6/2016/1739/MAJ and 6/2016/1740/LB

Email response from Conservation Officer

## **COMMENTS ON REVISED SCHEME MAY 2016**

Drawing Title  
PROPOSED CONTEXTUAL ELEVATIONS  
SHEET 1

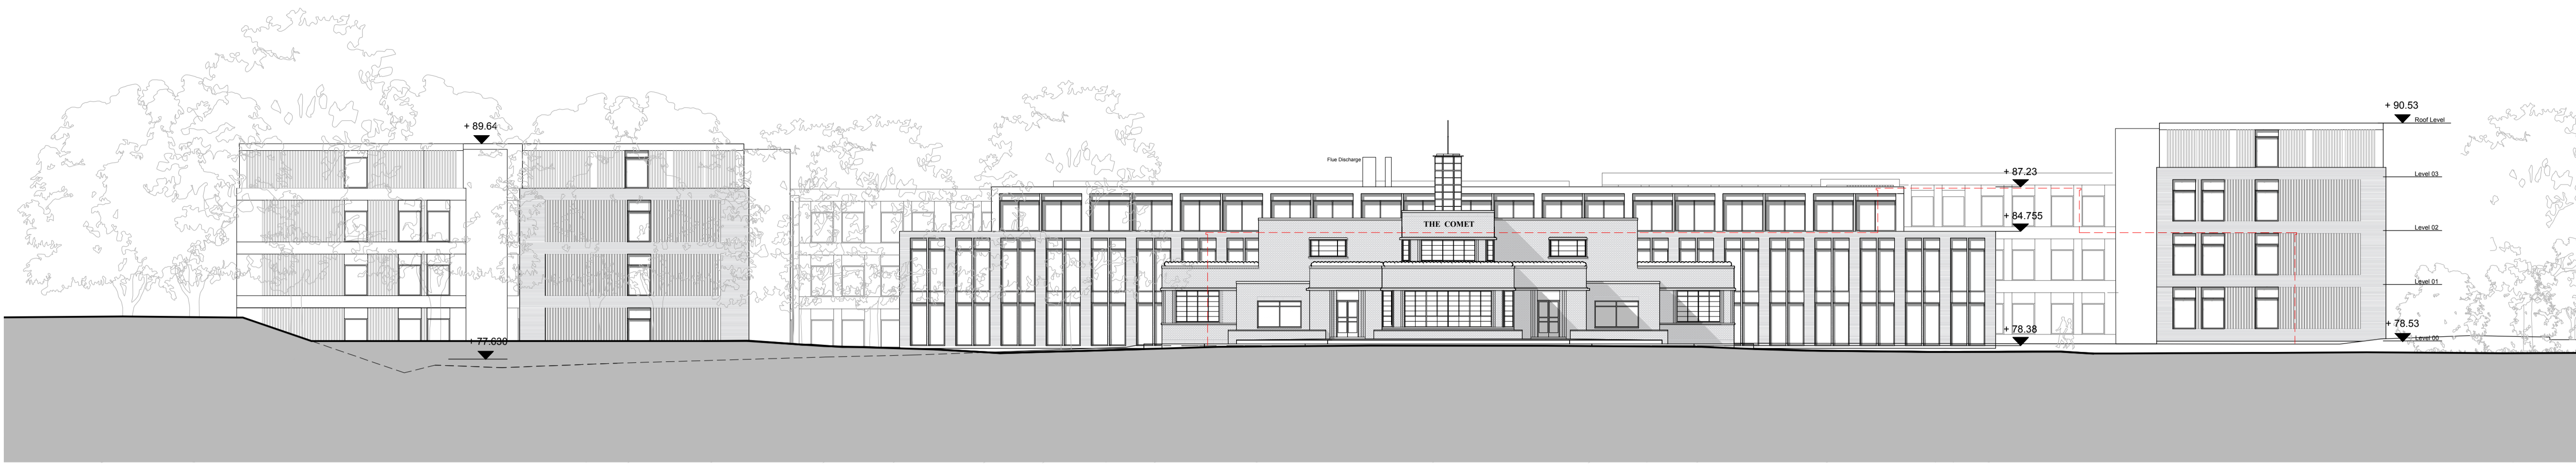
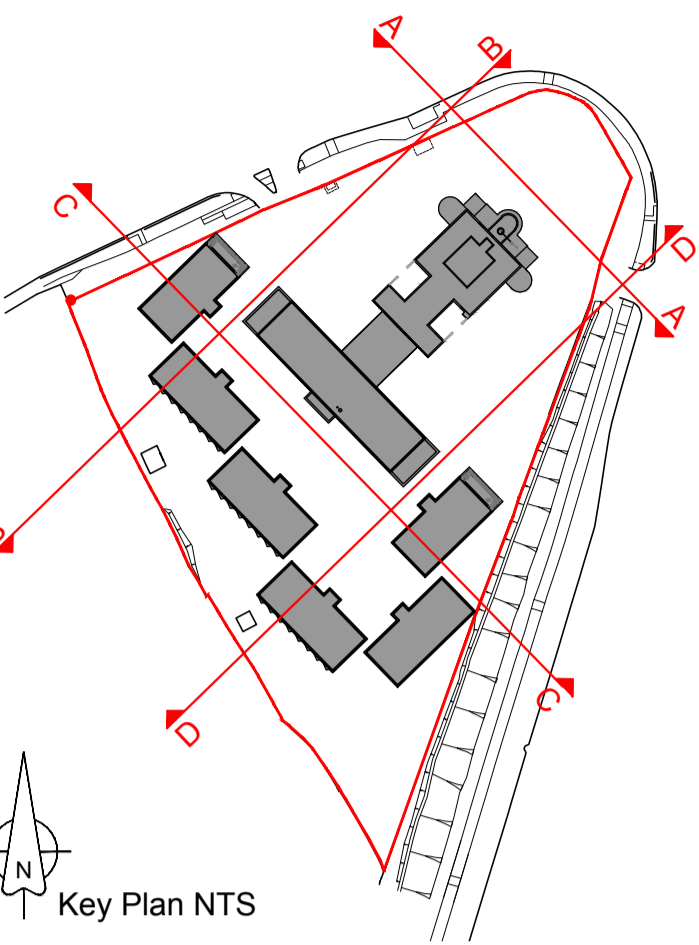
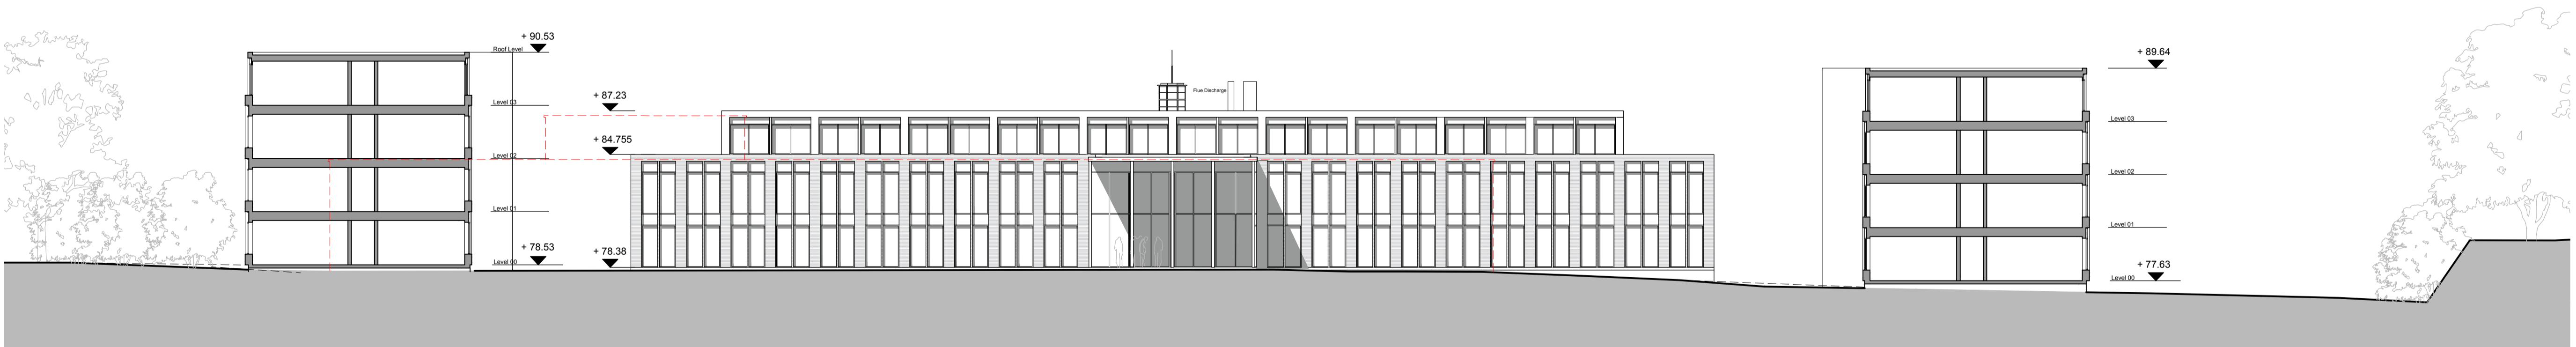
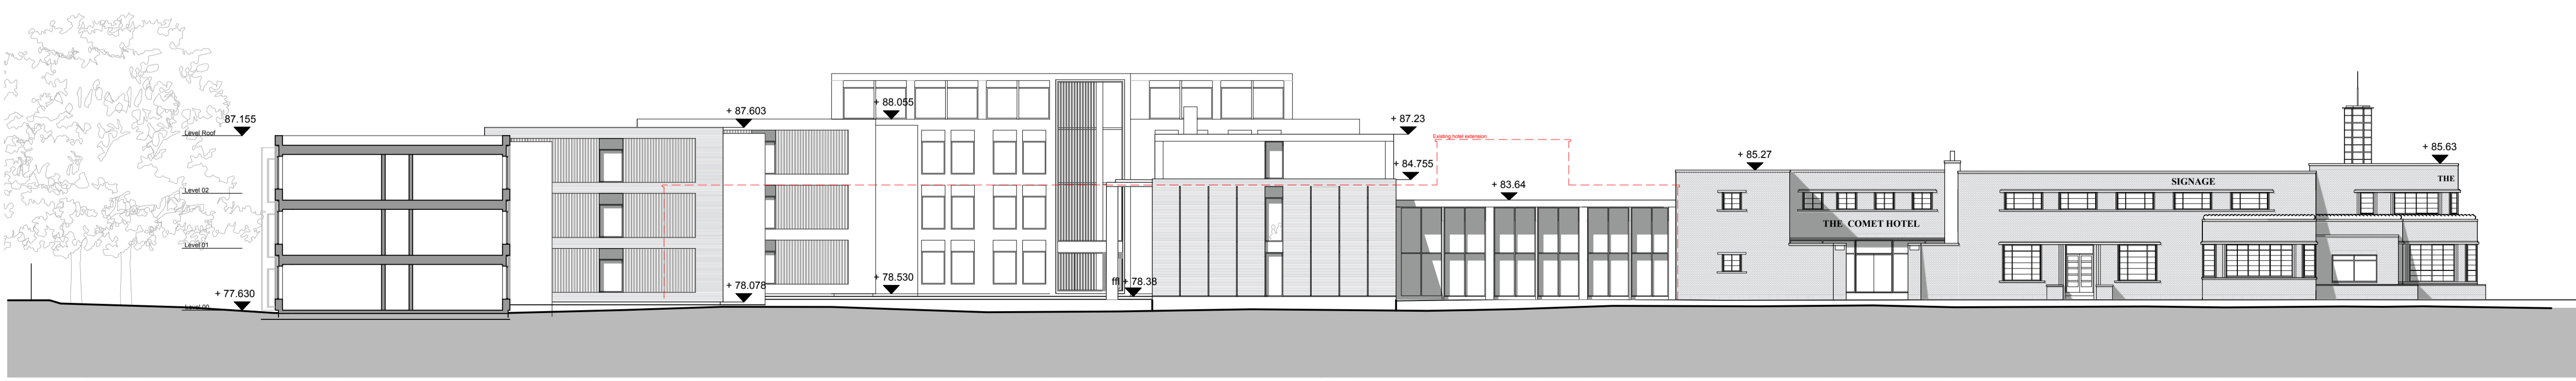
**In the new proposal, the NW block would remain at 4 storeys but the top storey would be set back perhaps a little more than previously. The SE block would**

be reduced from 5 to 4 storeys although strangely it appears more dominant than before from the main eastern view of the site because the existing trees that partially mask it are shown at a lesser size and if this is now the correct visual , somewhat disappointingly.

The crucial relationship between the listed hotel and its extension is in essence unchanged. The hotel remains 3 storeys and presumably 2.4 metres above the listed building and therefore fundamentally flawed. I have consistently made this point from the beginning of the pre-application meetings.

The change is to the materials and detailing. This is from a simple contrasting plain reflective glass clad building into a more modelled brick clad building. The previous treatment was more appropriate because it allowed the listed building to be seen against a plain backdrop. The new treatment would have the effect of subsuming it into a fussier background and it would therefore lose even more of its pre-eminence. The effect is made worse because the same brick treatment is continued over all of the student blocks as well. The desire to do it in art-deco style would also be a mistake in this case because the new building is so great in comparison to the listed building that it would be seen as an appendage to the new-build rather than the other way round.
